415 Cumberland Avenue

My apologies for the delay in looking at this, jumping on it first thing this morning. I have some comments on the Accessibility Evaluation that you can share with Archetype:

Residential Apartments

**A1.01**

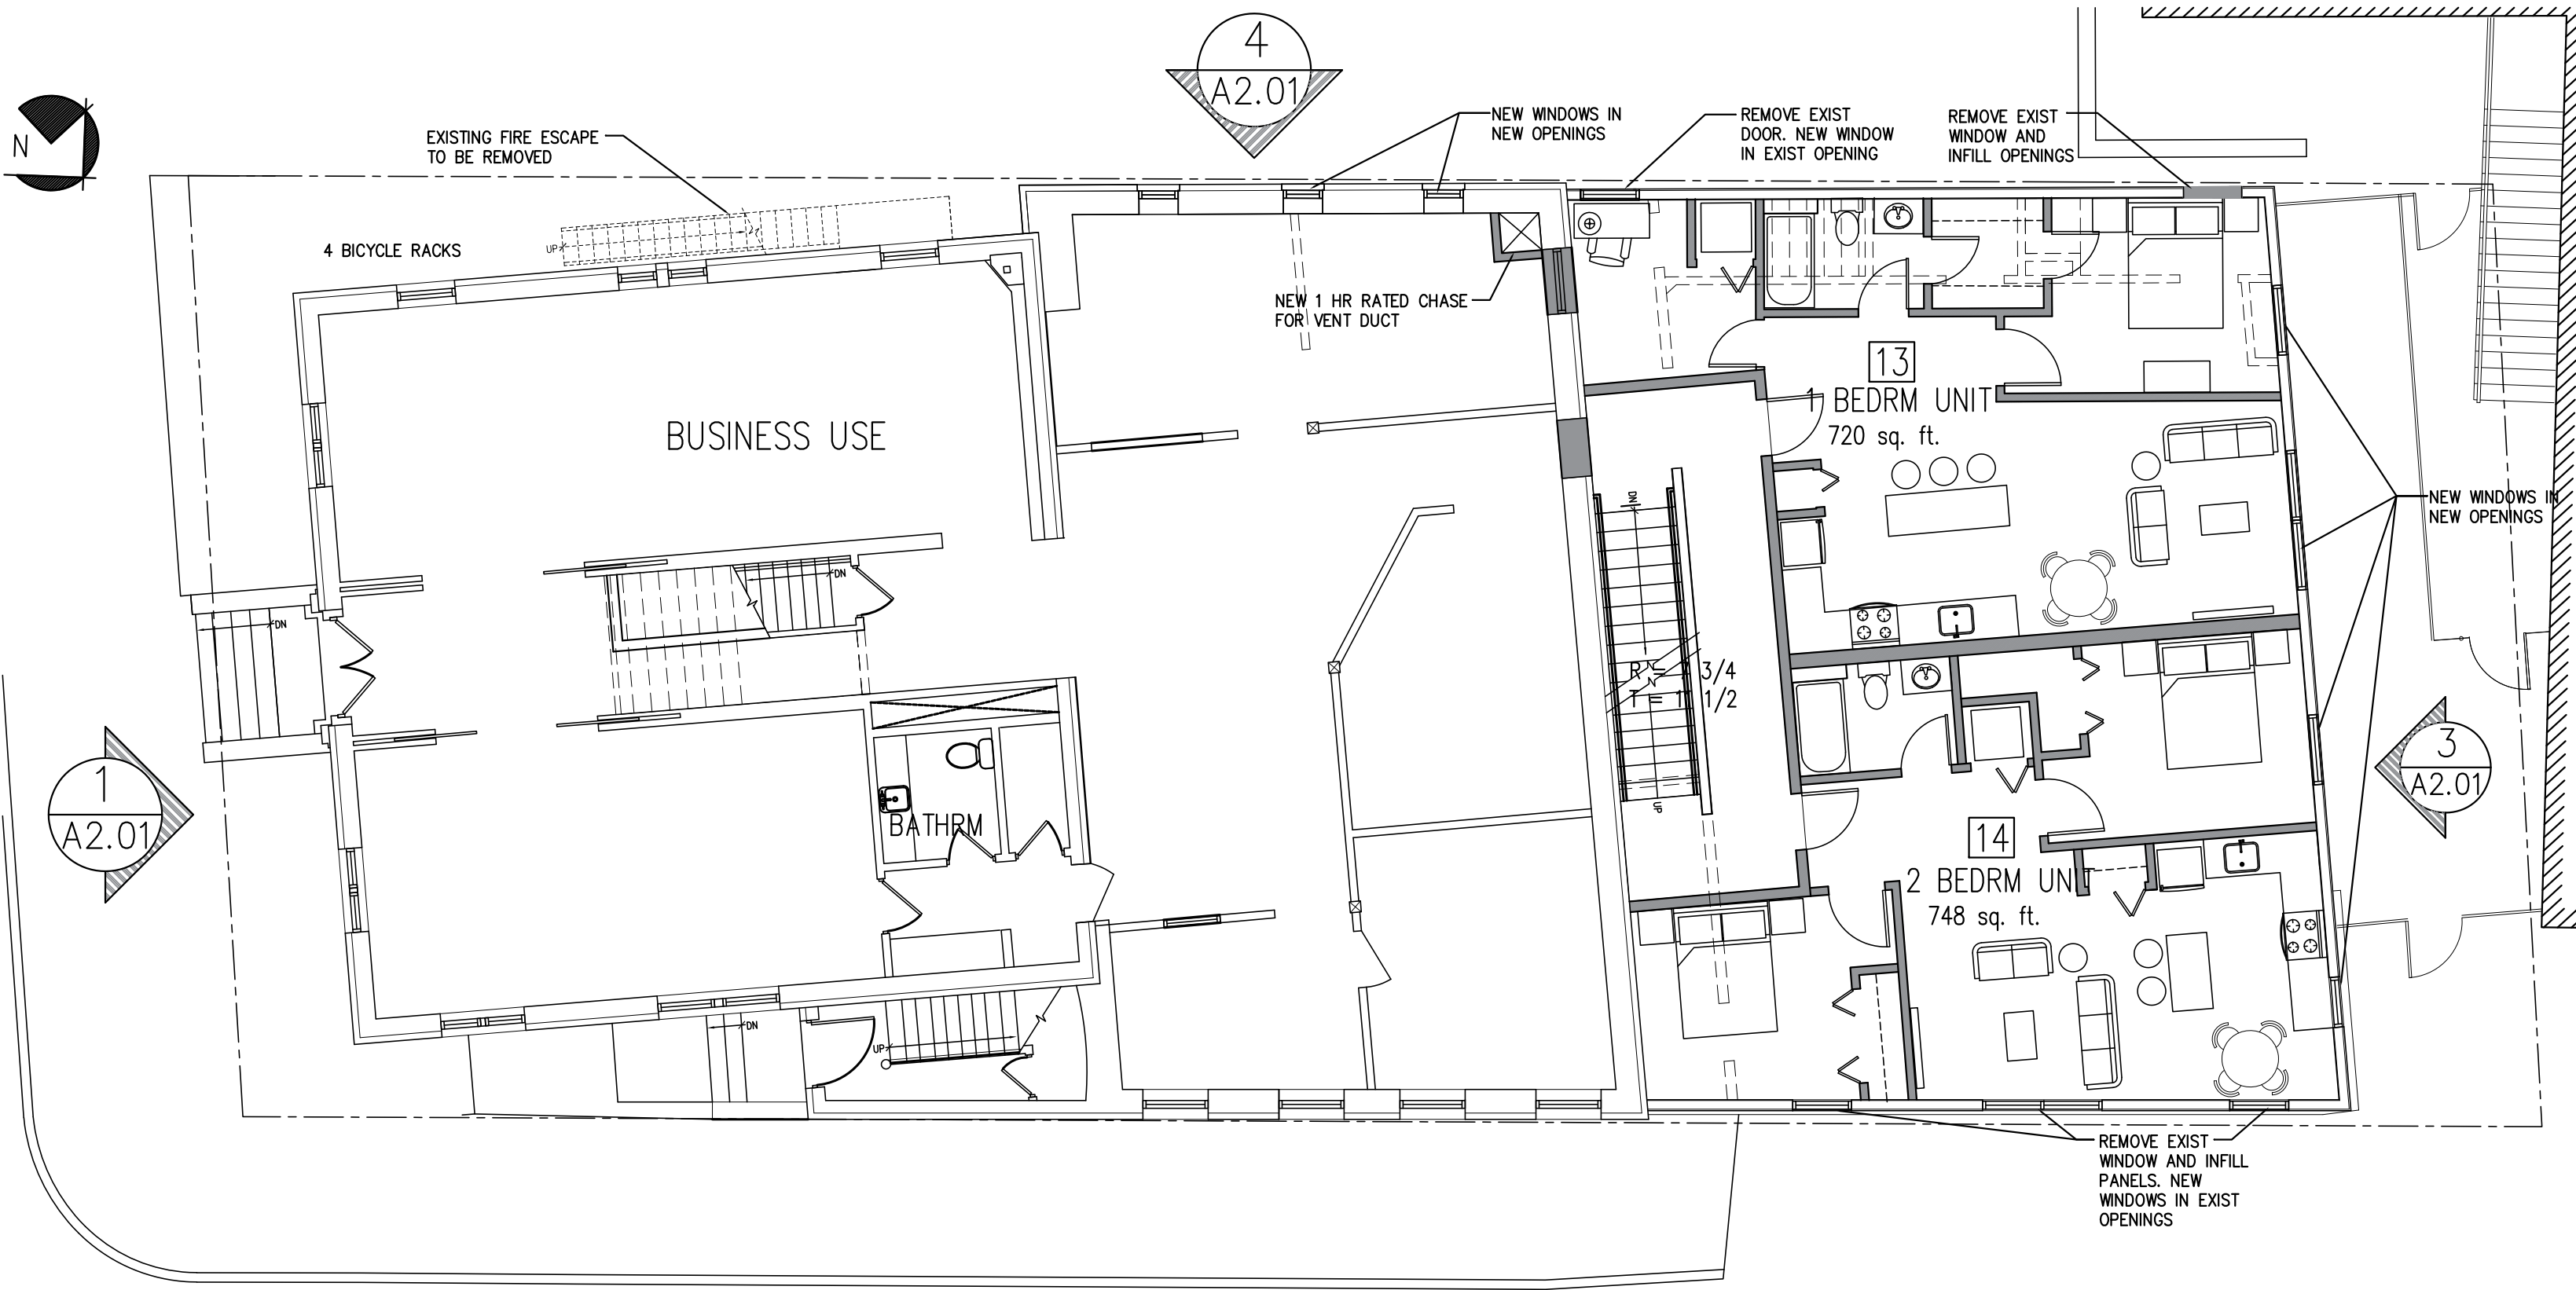
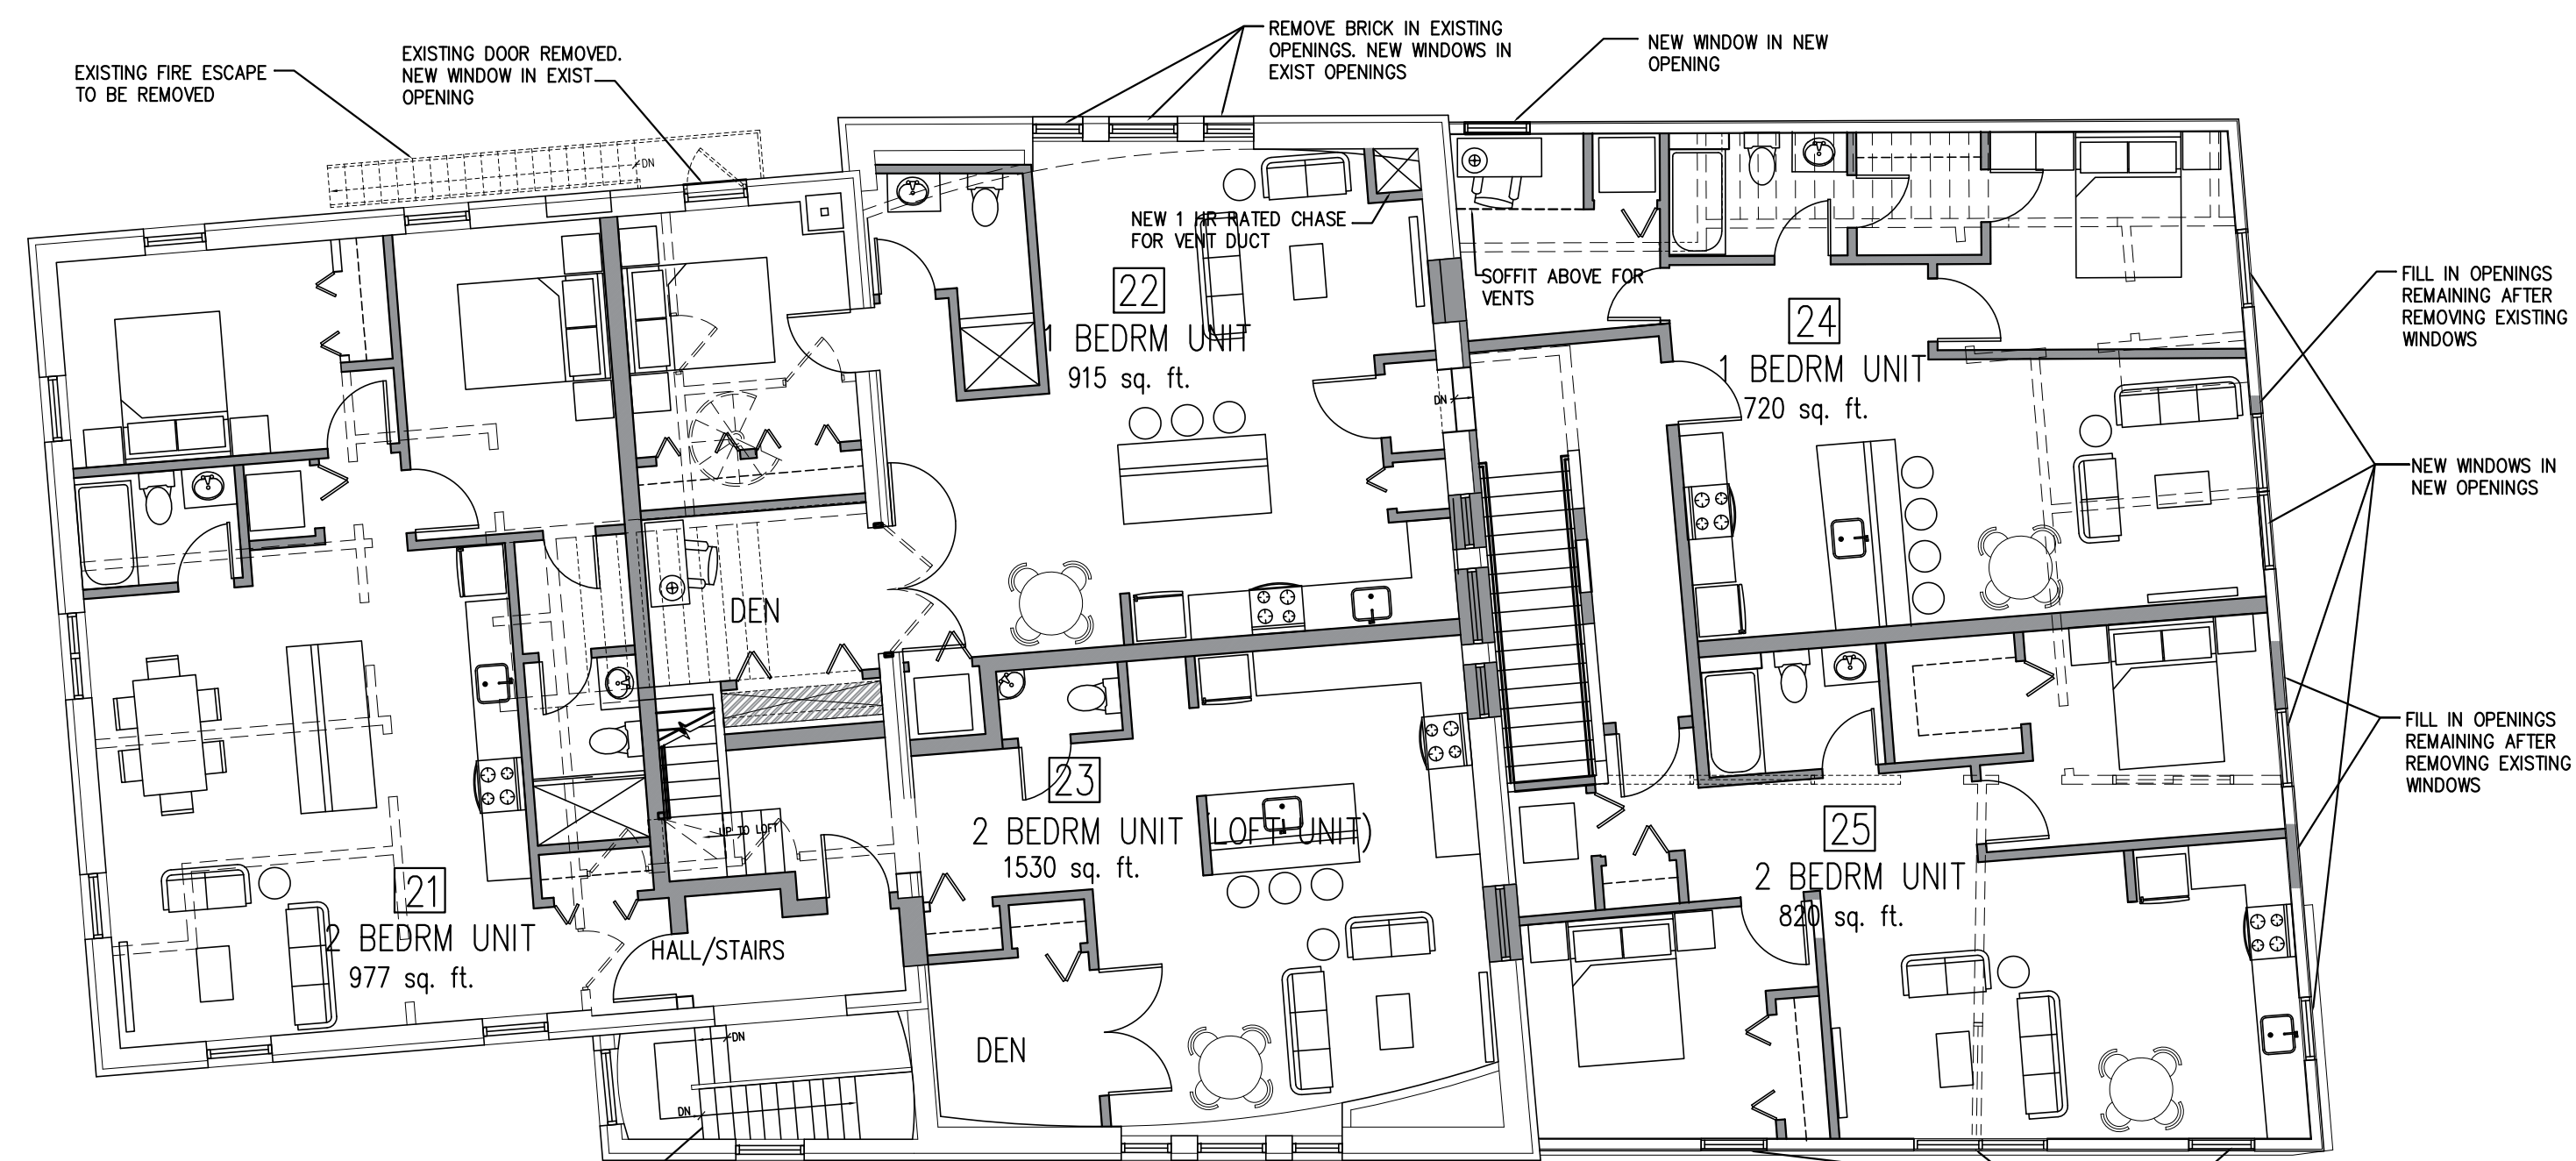
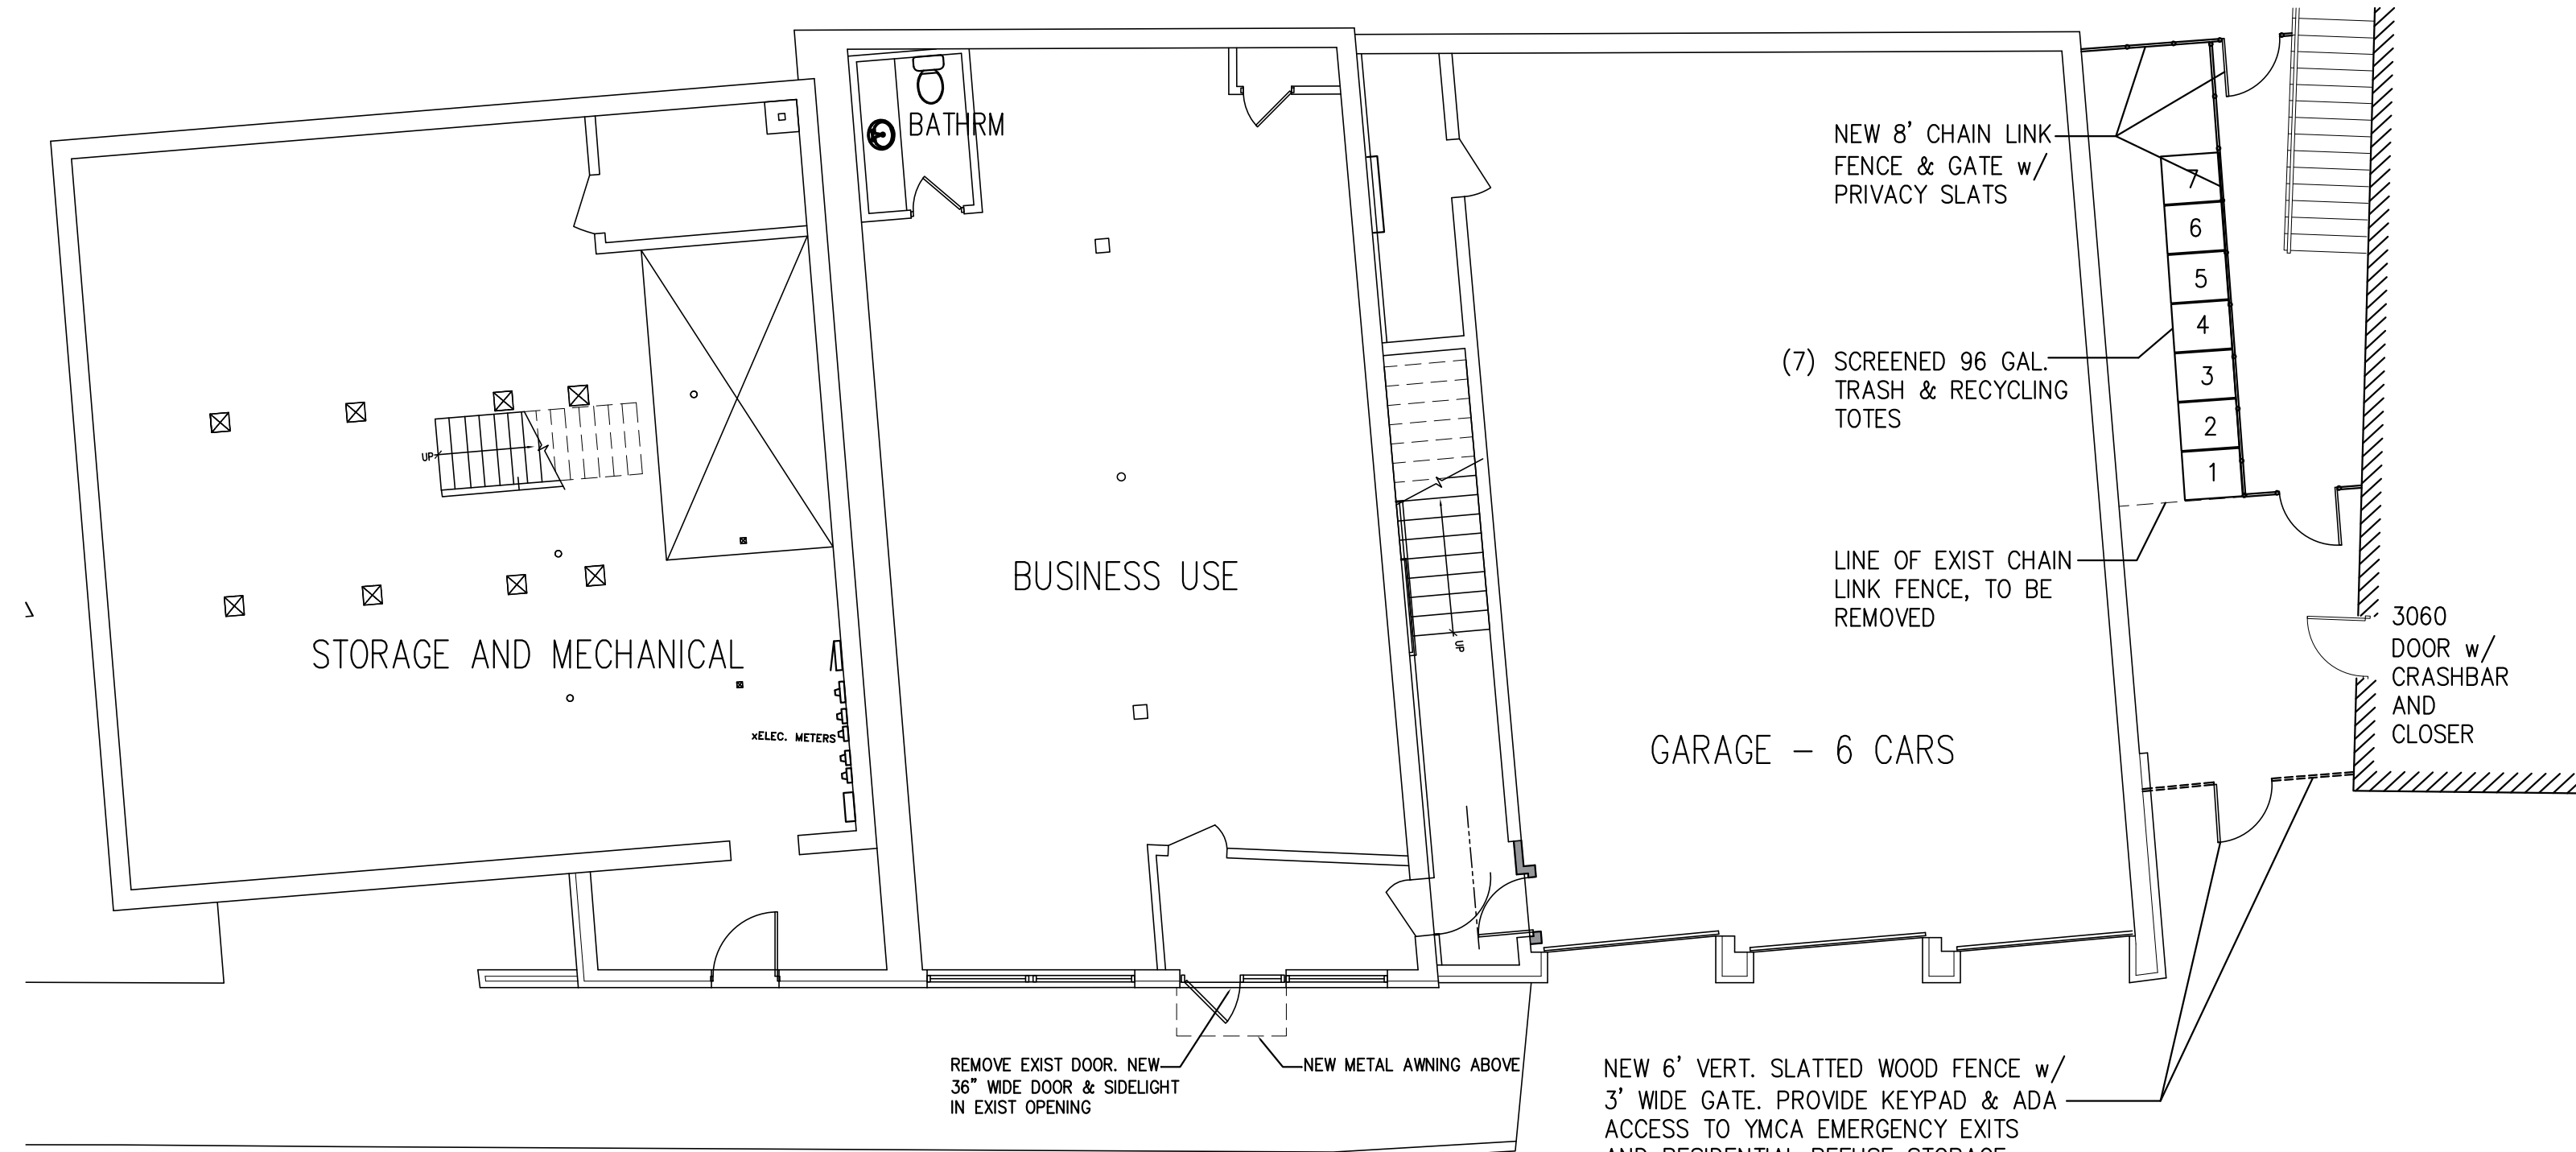
Note 6 as it pertains to Chap. 10 Change of Occupancy in IEBC 2015, Section 1012.8. As this requires compliance with Section 705, they will need to evaluate the following as stated in 705.1, "A facility that is altered shall comply with...705.1.1 through 705.1.14, and Chapter 11 of the IBC unless it is technically infeasible", so, pending any exceptions to this, it also needs to be addressed for Accessible Entrances per Sec. 1105.1.7 Dwelling units and sleeping units.

In terms of the plans, we have met with Barry Yudaken on 2 occasions to review the code implications. I just got an email from him last Thursday with some proposed changes in the design, to have the penthouse be a separate unit instead of part of the 2nd (3rd) floor unit. Jason and I will need to take a look at the latest plans for compliance.
